Smart Motorways Programme

M4 J3 – J12

Package 1 (J8/9 to J12) Designer's Response to Road
Safety Audit (Stage 2)

Document Number: HA514451-CHHJ-GEN-S1_ZZZZZZZZ_Z-RP-ZZ-0004

EA Reference E9-A2

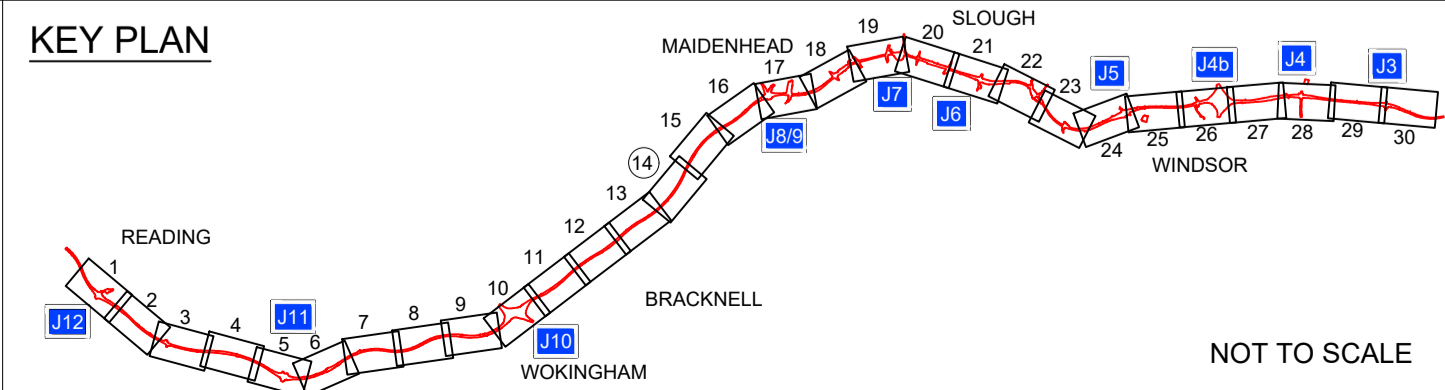
Location: EA E9-A2 (Drawing HA514451-CHHJ-HGN-S1_ML000000_Z-DR-CH-1014 Rev C02 Sheet 14 of 91) M4 westbound (chainage 58000)

Summary: Reduced visibility to emergency area E9-A2 may lead to conflicts

Forward visibility to the ½ mile EA sign for EA E9-A2 is potentially restricted by the parapet for Mortimer Line Railway underbridge depending on the mounting height of the sign. Drivers intending to use the EA may not appreciate its position increasing the risk of a live lane stop collision.

It is recommended that the sign for the EA is mounted so that the bridge parapet does not obscure the sign face.

The mounting height of the sign will be reviewed on site and, if required, adjusted to ensure visibility can be achieved.
